From: Christina Wollman
Sent: Wednesday, November 26, 2014 11:52 AM
To: Kaycee Hathaway
Cc: Dave Nelson
Subject: Sun Dog Short Plat

I have requested additional information from the applicant regarding the Sun Dog Short Plat. The issue is that during review of the original Take Five Plat, access to the lots was identified by the surveyor as roads D and H, which are 60' easements. This was acceptable.

### SUN DOG SHORT PLAT

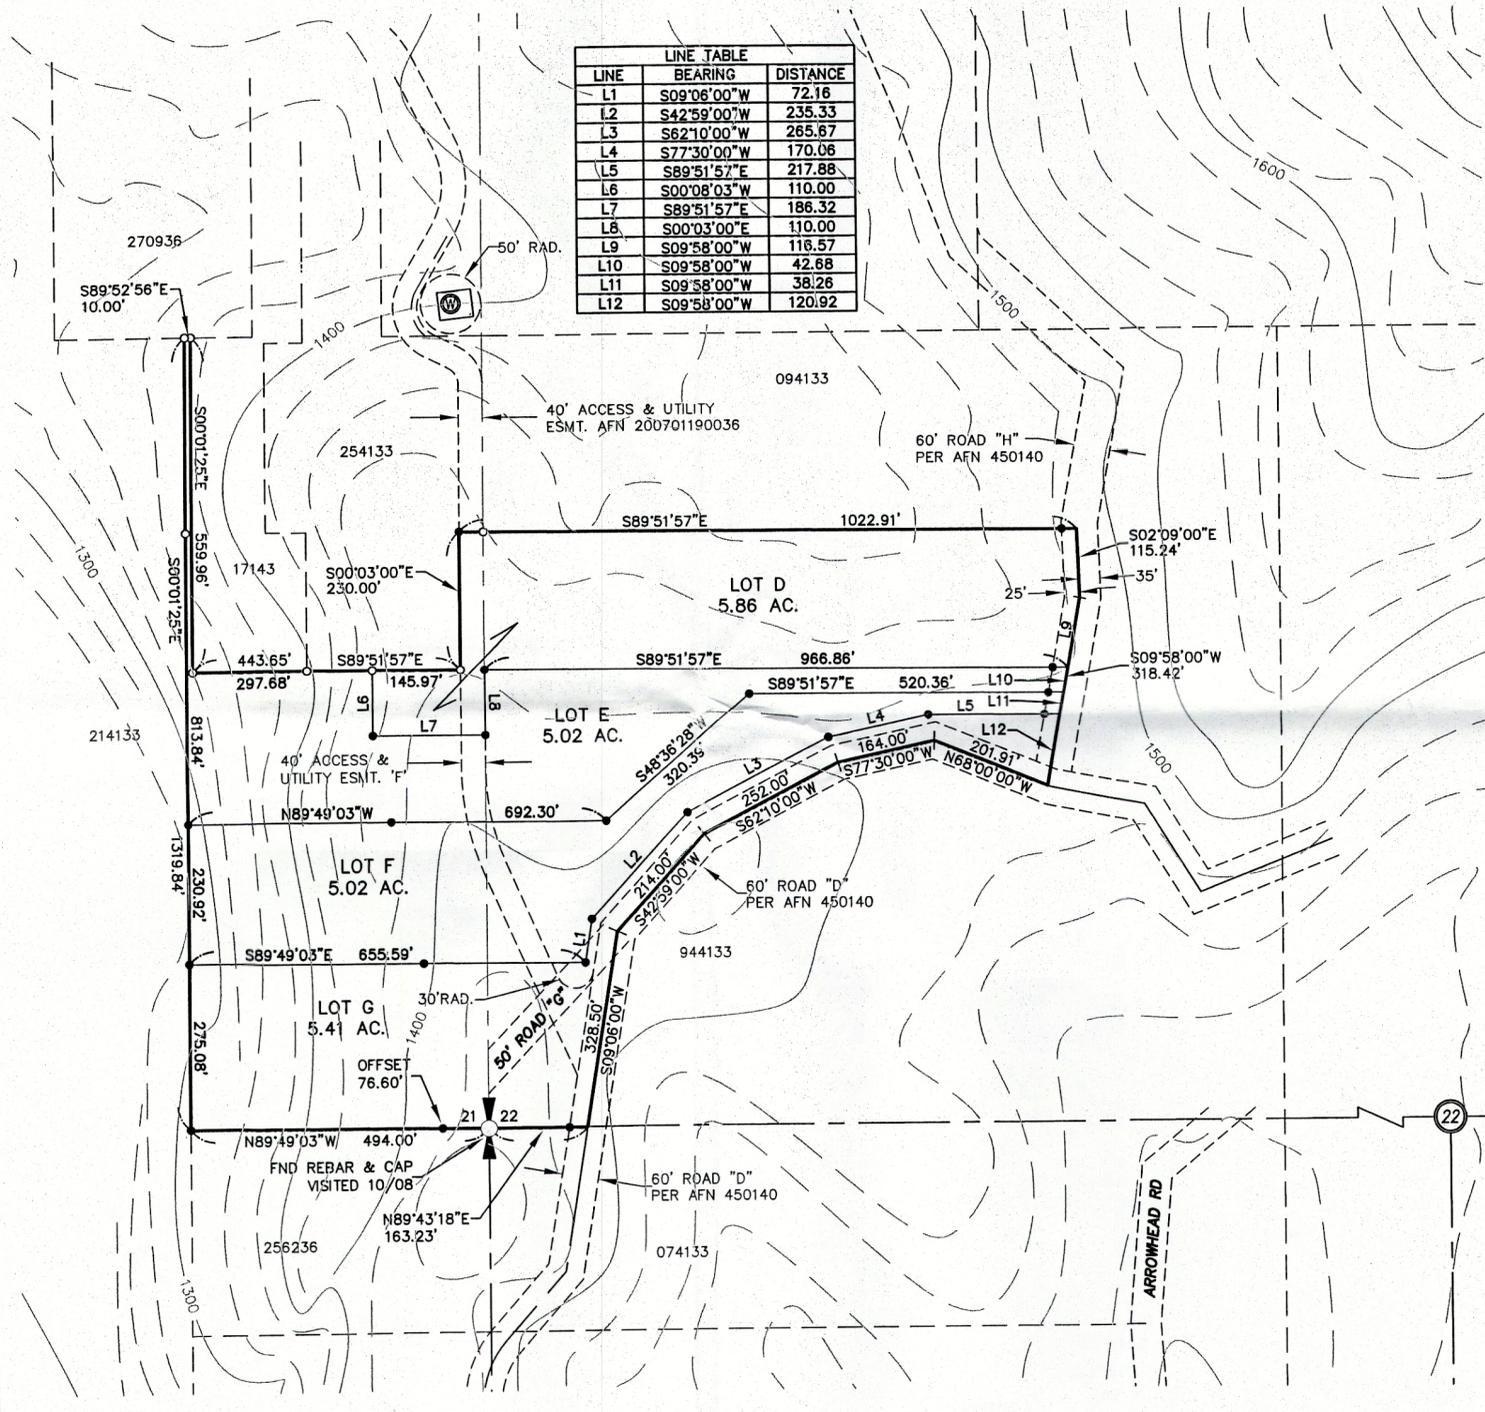
Today, if you look at aerial photos it looks like there are building sites and driveways coming off road F, which is only a 40' wide easement. The average lot size in this development is greater than 5 acres and a 60' easement is required.
